NSIP EXAMINATION : EAST PARK ENERGY				Date: April 2026 (Deadline 2) Rev.: Rev3 13 July (Management Plans > D4) Status: For Information Author: Peter Dijkhuis																		RAG Review

REPORT 1: RELEVANT REPRESENTATION (Date: 14.01.2026) 1.1 Pre-application Issues Tracker (work-in-progress) 1.2 Potential Main Issues for the Examination (marked as Red)				Red (High Risk): Fundamental issues with the assessment, methodology, or scheme that are unresolved and could significantly impact the Examination or delay the decision. (BBC Red: read as a Significant Material Consideration) Amber (Medium Risk): Outstanding issues where disagreement exists with statutory bodies/ Host Authorities (e.g., Natural England, EA), but a resolution is identified/ can be attained.. (BBC Amber: matter MAY impact on layout/ land optimisation - resolution can be attained) Green (Low Risk): Issues that are considered resolved or agreed upon with relevant stakeholders. (BBC Green: matter can be resolved at post Examination)				Applicant Review Revert on RR (Deadline 2: 28April) RAG as assessed by BBC		REPORT 2: LOCAL IMPACT REPORT (Local Perspective: Examination/ April) Content: Detailed local knowledge; ass

D01: Proposed Dust Monitoring Locations (DMP1 – DMP10)

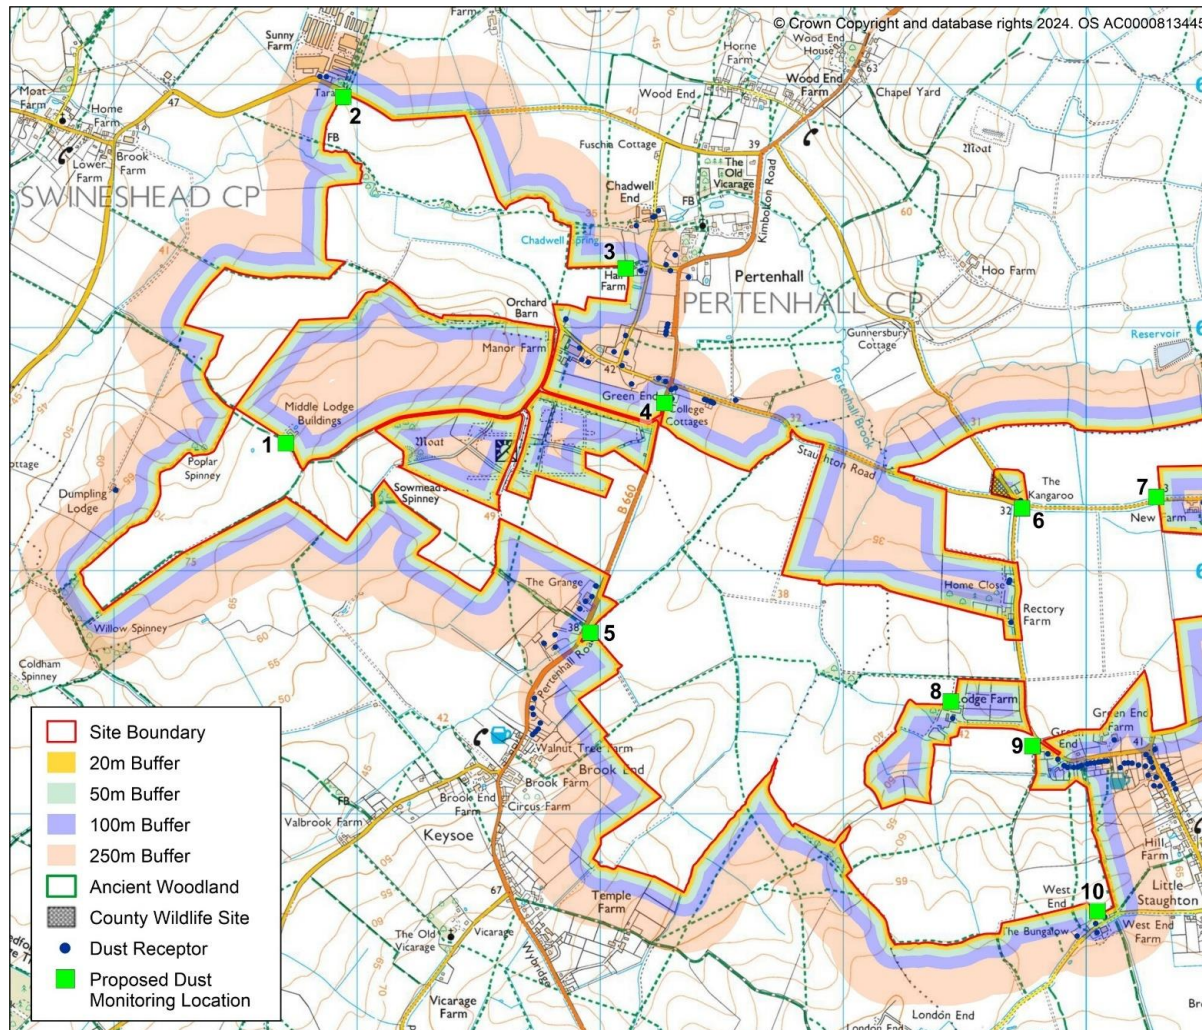
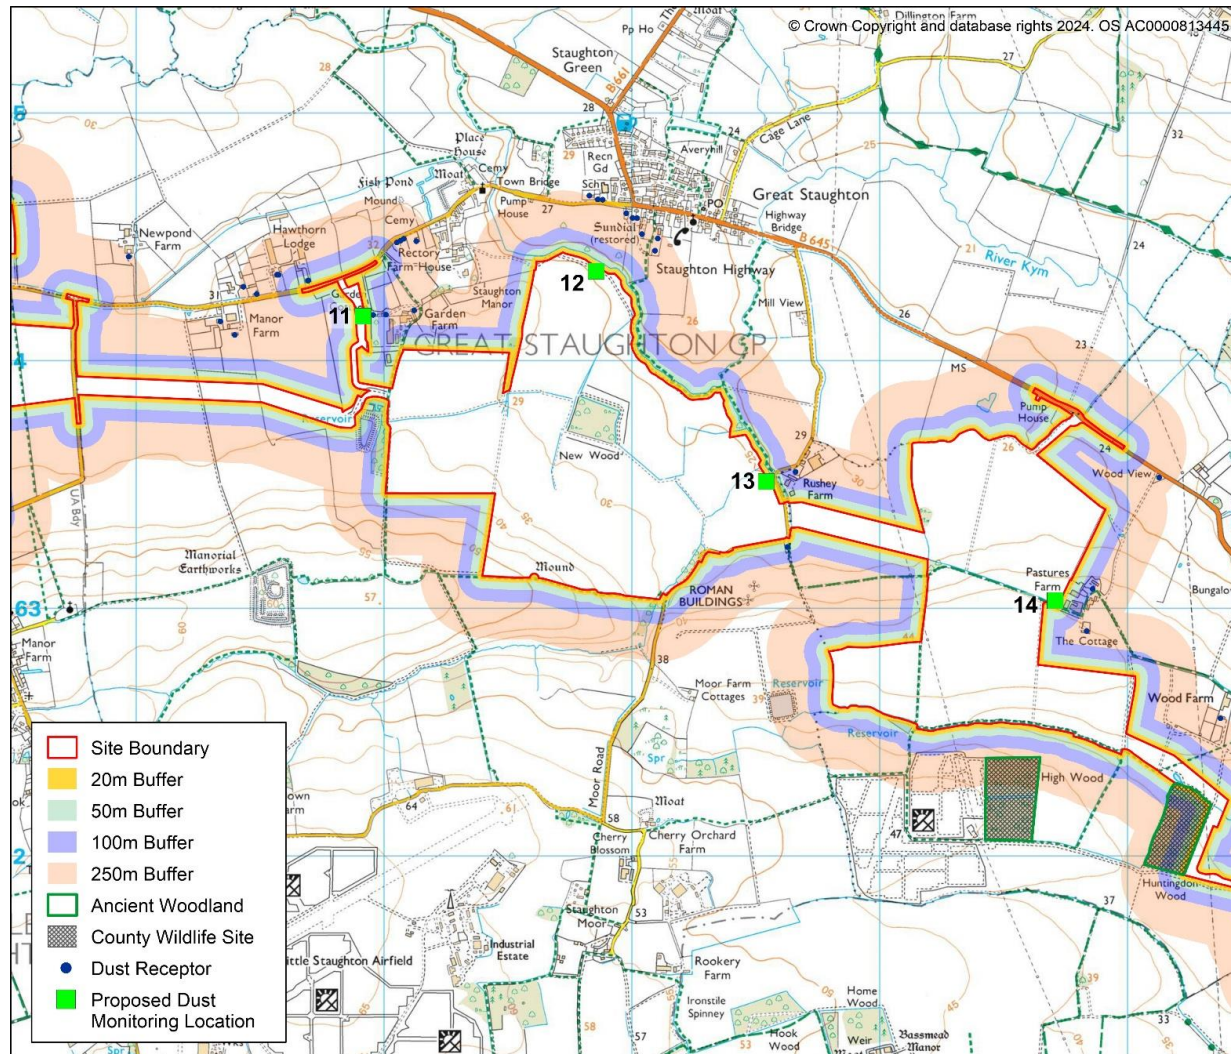
133	74 LIR14.4	Dust mitigation, mitigation measures... during dry months: - address	Host Authorities	APP-157 (T5.7)		During		Significant	Host	Medium-term	Irreversible	Periodic	Eliminated	Address via Management Plan	BBC to review oCEMP [REP1-036] + Construction Dust Management and Monitoring Plan (oCDMP) within Appendix A of the oCEMP [REP1-032] + Decommissioning Dust Management Plan (DDMP) part of DEMP	36				
134	Chp.12: Ground Conditions (Land and Water Contamination)	Pollution leaching, Environmental Incident Management and Pollution Prevention Plan: - address	Host Authorities; EA; LLFA	BBC Scoping (2023); PINs Scoping (ID3.3.2; 3.4.4; 3.4.5); APP-048(12.7.3); APP-157; APP-158(T5.8)		During		Significant	Host	Long-term	Irreversible	Continuous	Eliminated	Address via Management Plan	Environmental Incident Management and Pollution Prevention Plan (EIMP) - to be submitted post consent: Matter for ExA	36				Concluded
